McPhillamys Gold Project: Adequacy of Environmental Assessment

I refer to the correspondence dated 9 September 2019 inviting the Resources Regulator to provide advice regarding the adequacy of the McPhillamys Gold Project Environmental Impact Statement (dated 27 August 2019) for McPhillamys Gold Project.

The Resources Regulator advises the Department of Planning, Industry & Environment – Resources Assessments that the SEARs for Rehabilitation have not been adequately addressed in the McPhillamys Gold Project Environmental Impact Statement (dated 27 August 2019) for Project McPhillamys Gold Project, dated 9 September 2019.

McPhillamys Gold Project  
Amendment report – rehabilitation and  
landscape management strategy addendum  
Figure 3.1

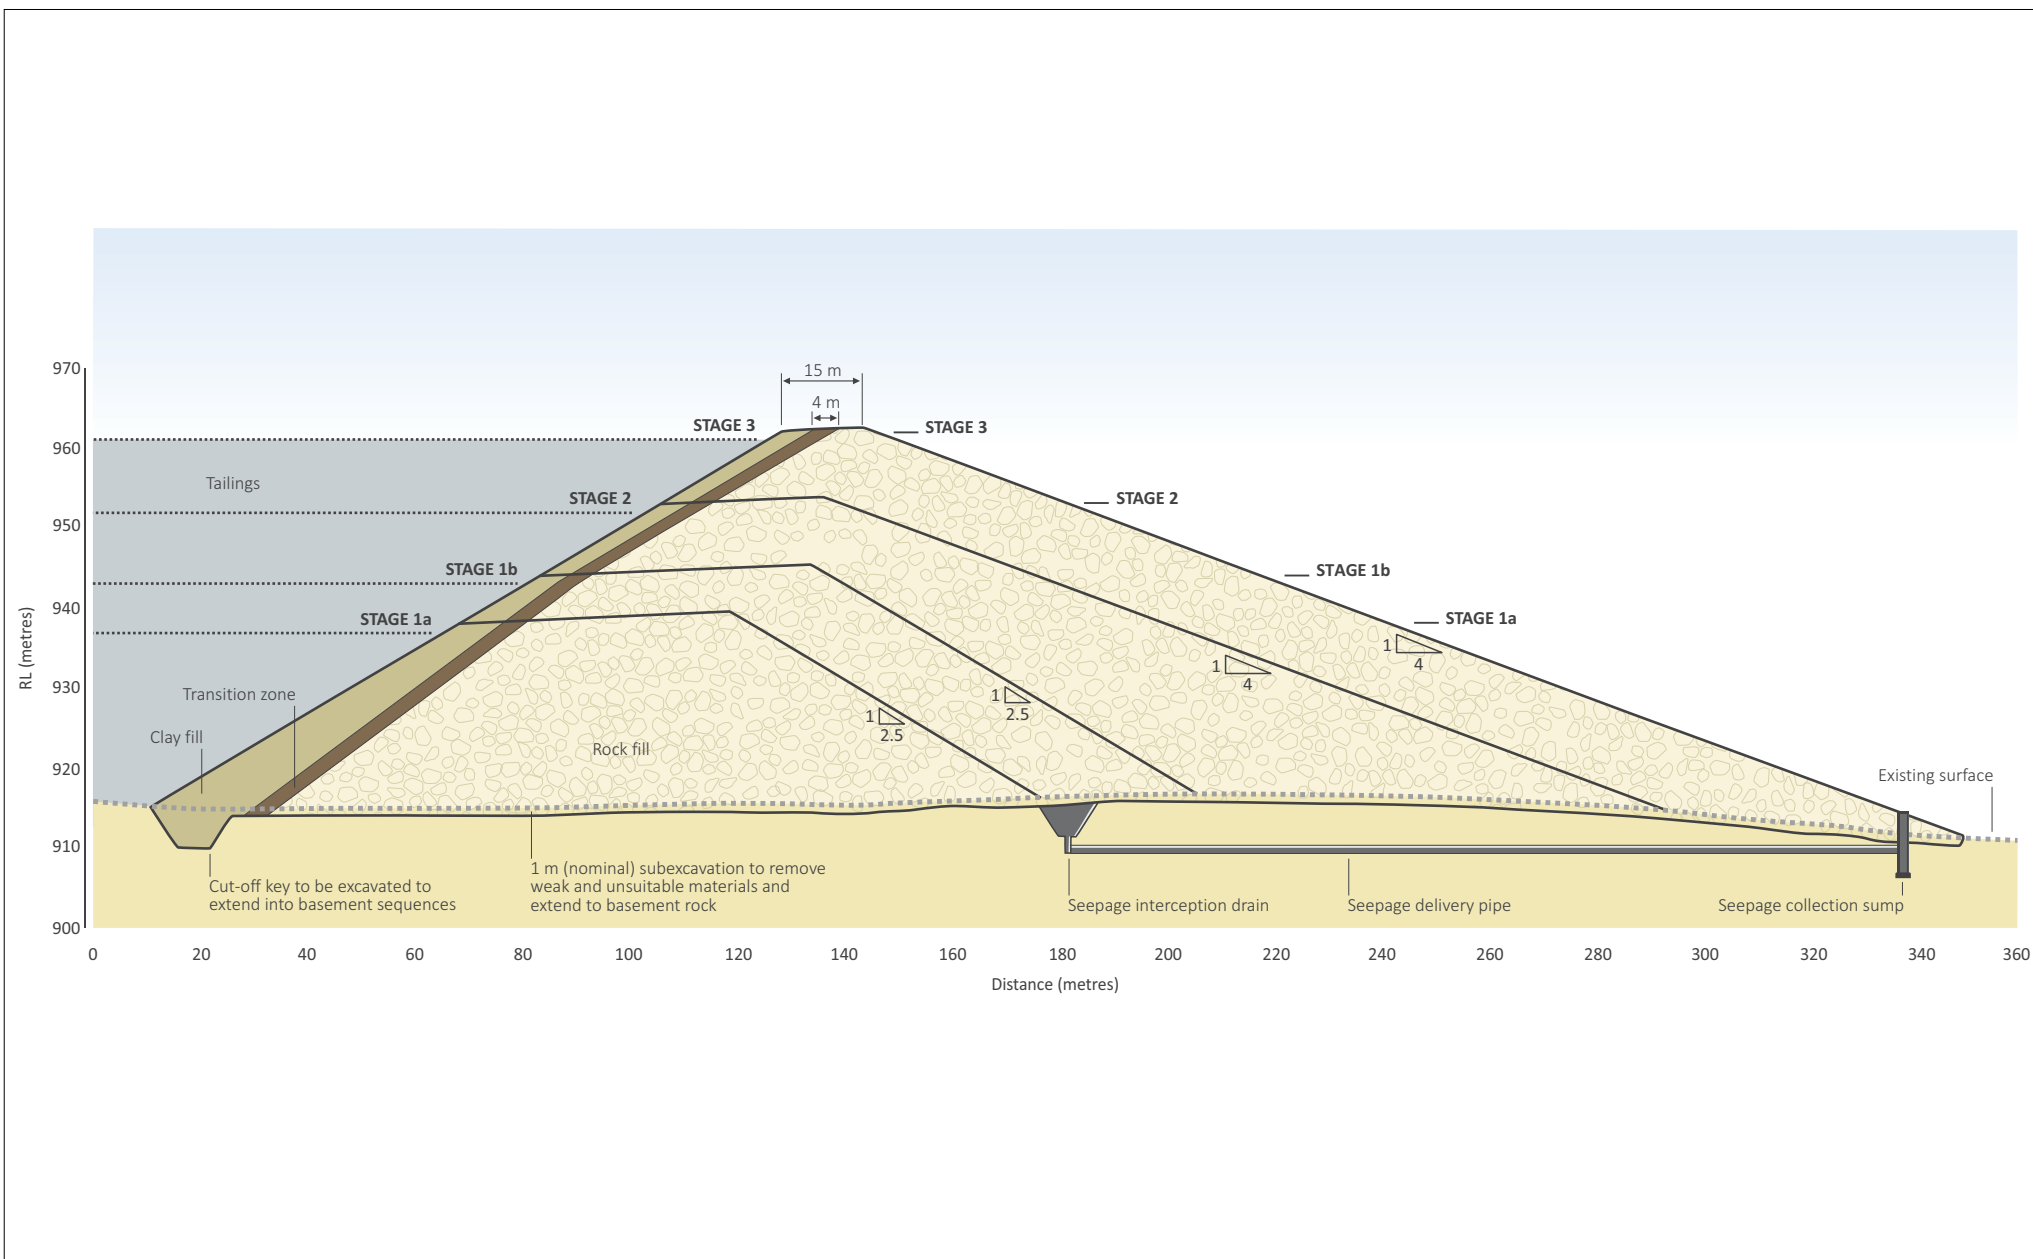
b) more detail regarding final capping design including how final landuse can be achieved with proposed capping and cover design since grass cover is proposed on the TSF but consideration of trees potentially naturally establishing on the TSF post-closure has not been provided.

McPhillamys Gold Project  
Amendment report – rehabilitation and landscape management strategy addendum  
Figure 4.3

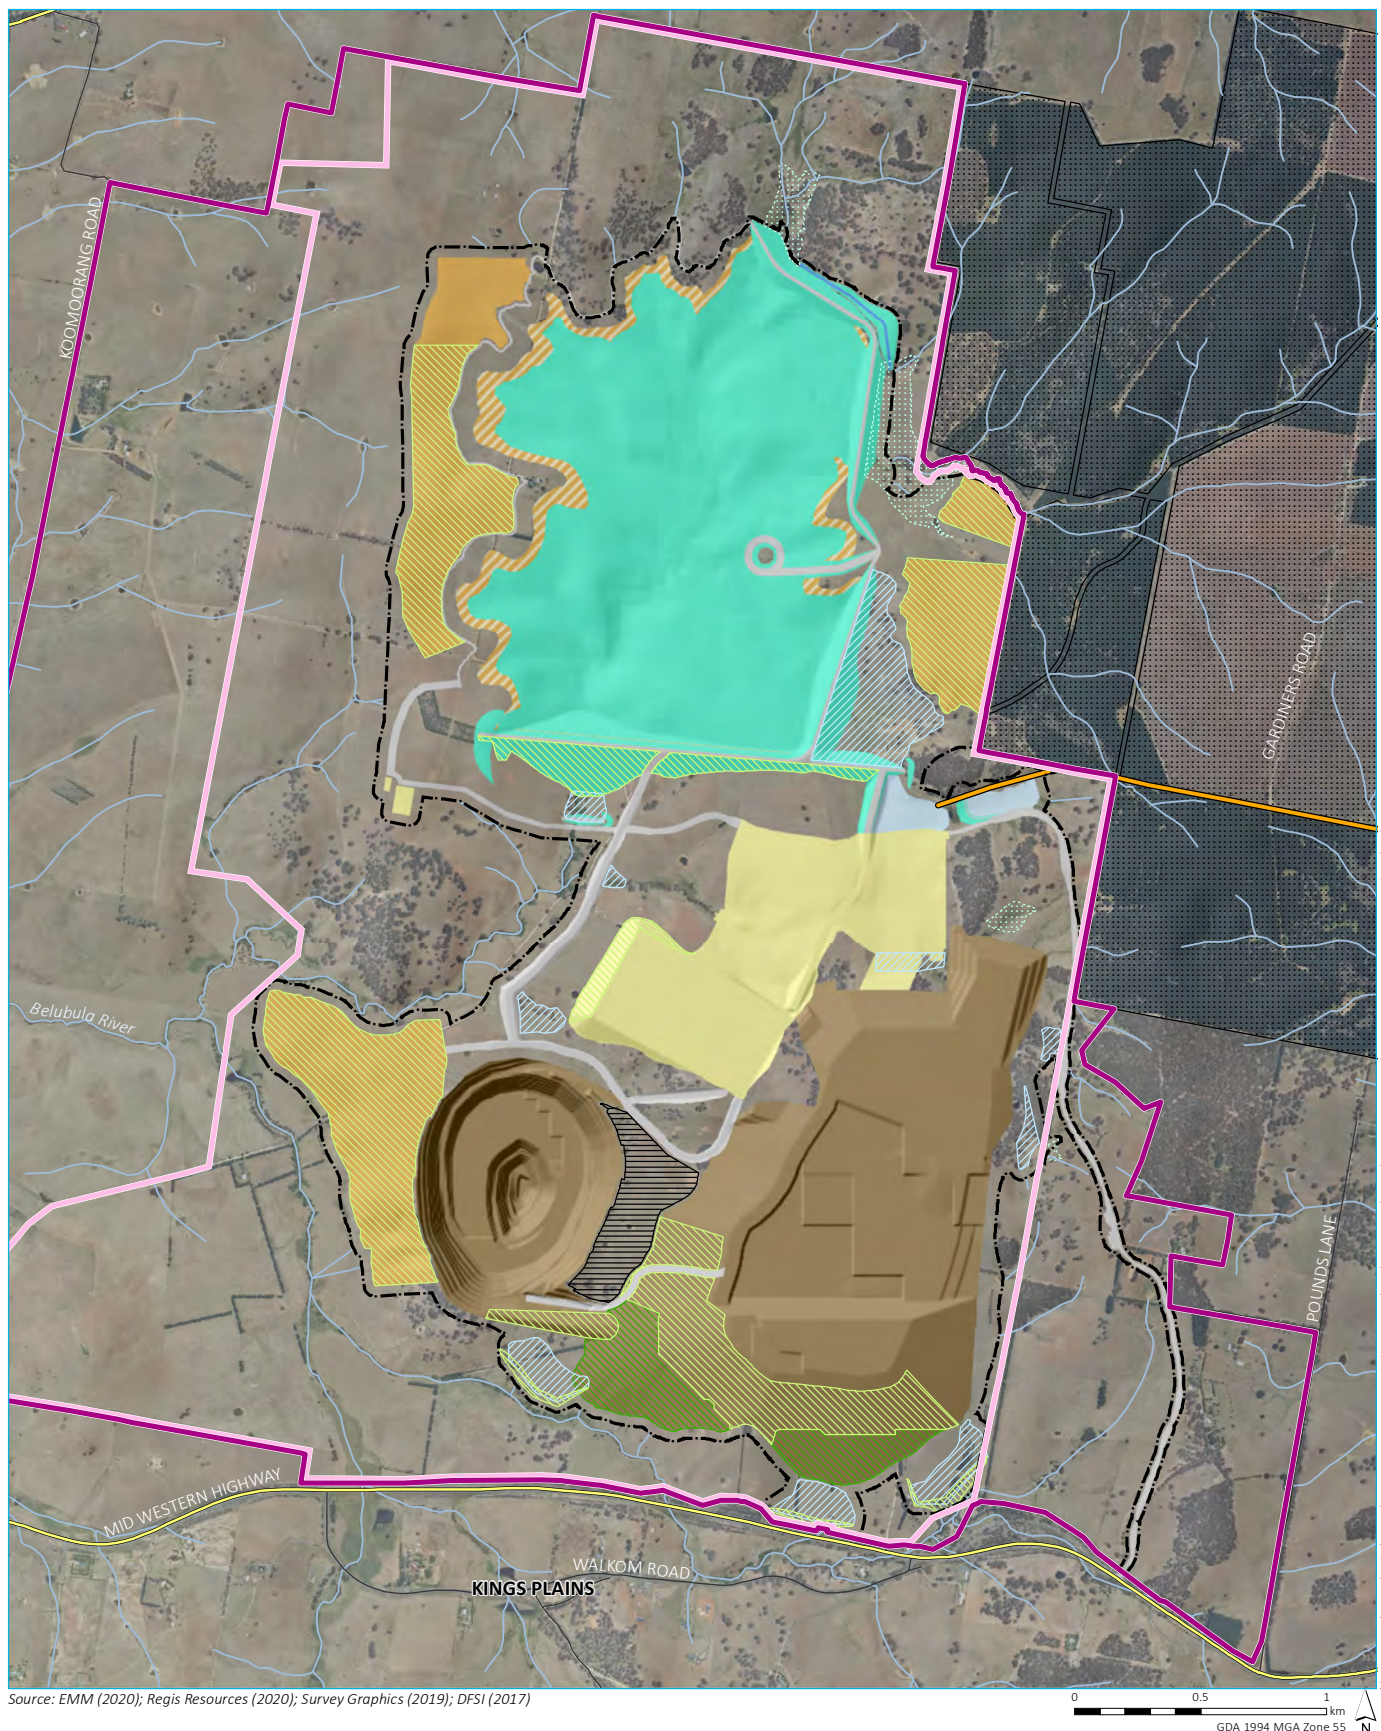
a) An indicative project schedule and diagrammatic representation of rehabilitation progression is provided. However, further information is

required on the range of assumptions behind the life of mine rehabilitation schedule to determine whether opportunities for progressive rehabilitation have been maximised.

McPhillamys Gold Project  
Amendment report – rehabilitation and  
landscape management strategy addendum  
Figure 4.7

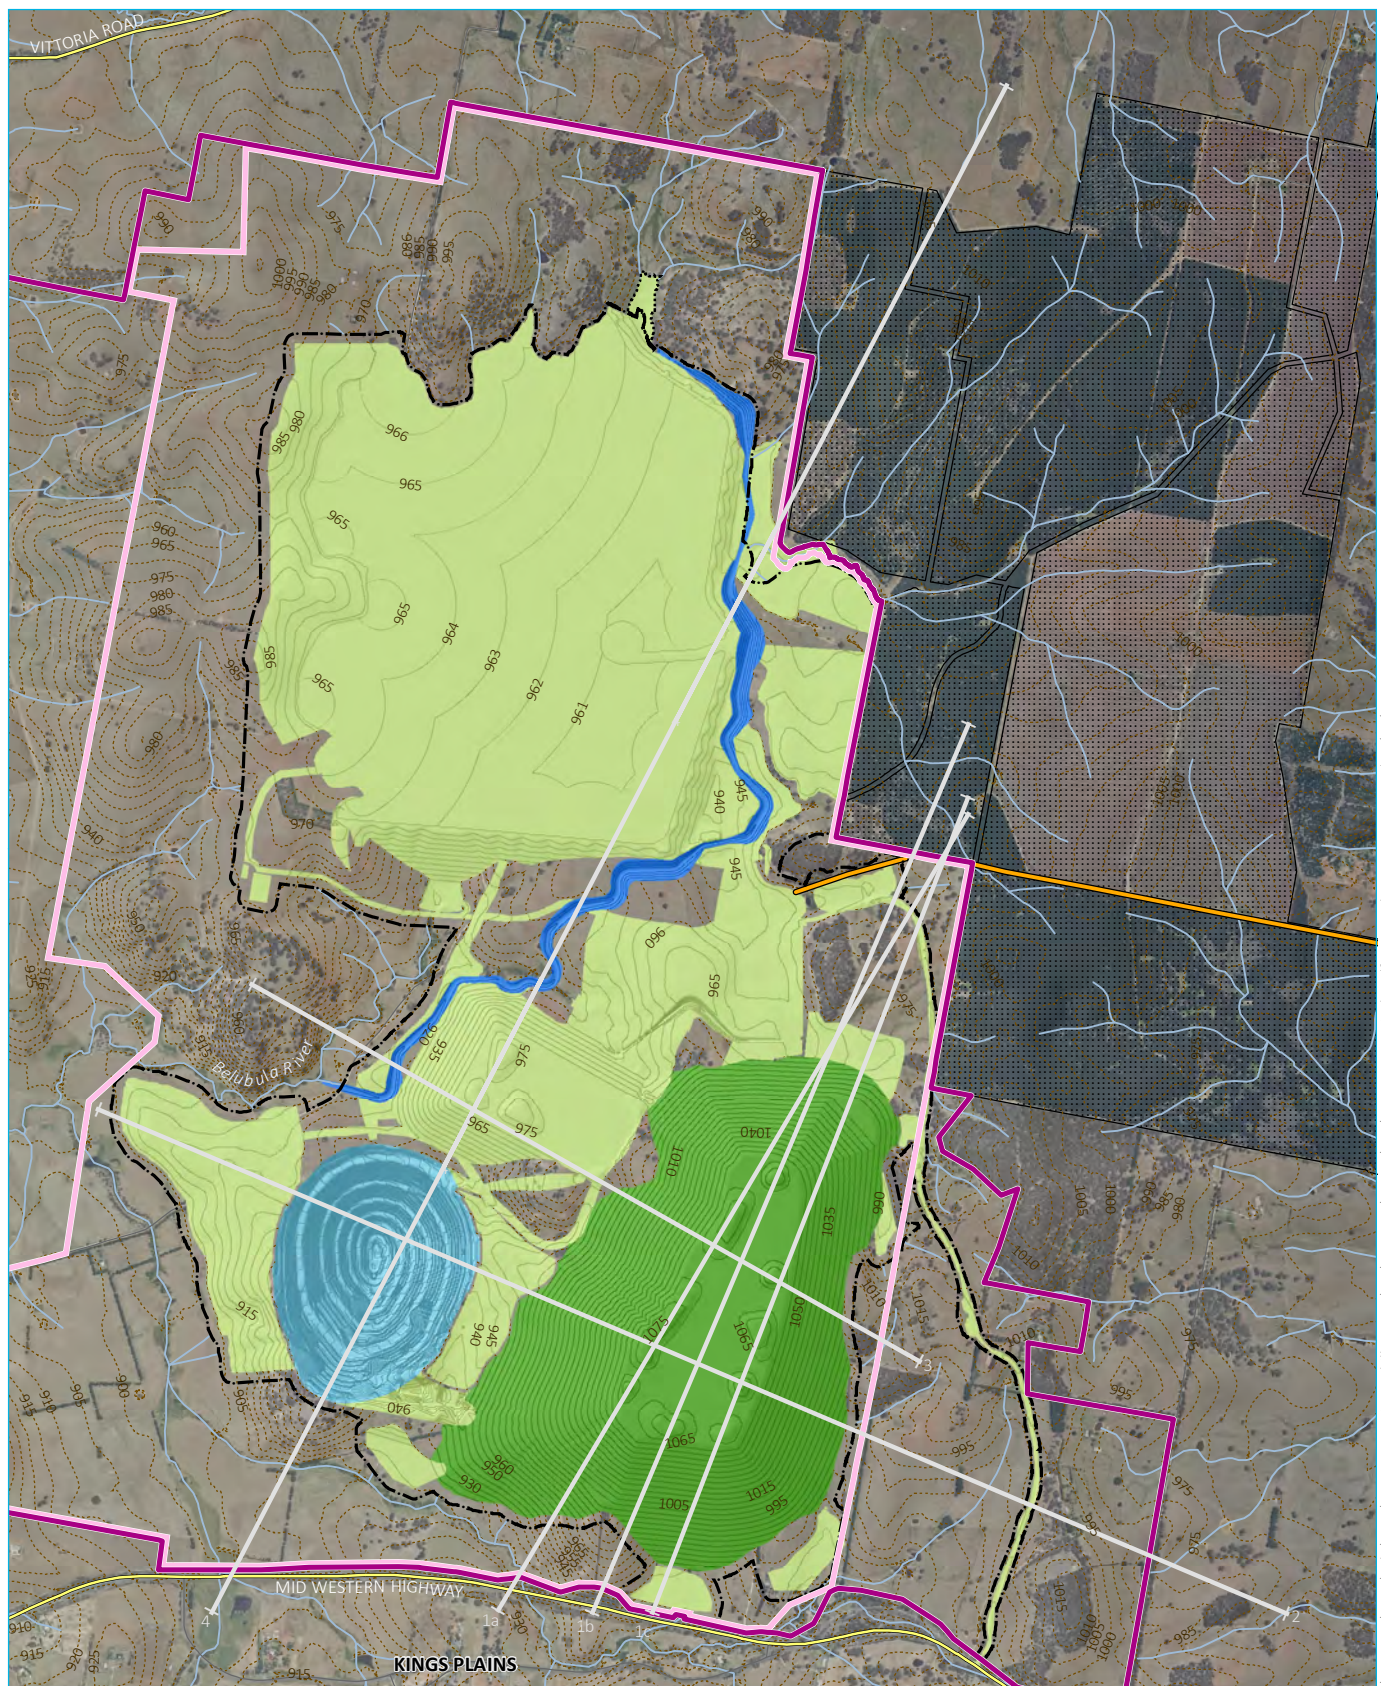
a) Figures provided in the EIS and Appendices do not provide an adequate level of detail for the TSF, WRE and ROM final landform. Provide drawings at an appropriate scale of the WRE and ROM final landform including, but not limited to, the following:

- i. Plan view
- ii. Section views, including reference to surrounding natural topography and any other proposed landforms or infrastructure.
- iii. Contours including labels (where appropriate)
- iv. Dimensions and slopes
- v. Structures and materials

b) In support of the drawings requested above, provide an overview of the key characteristics of the final landform for the TSF, WRE and ROM. Based on the characterisation of materials, the overview should include a discussion on capping strategies; the source of associated capping material and associated volumes that may be required; and measures that will be implemented to ensure a sustainable post-mining landform that is commensurate with the surrounding natural areas is achieved.
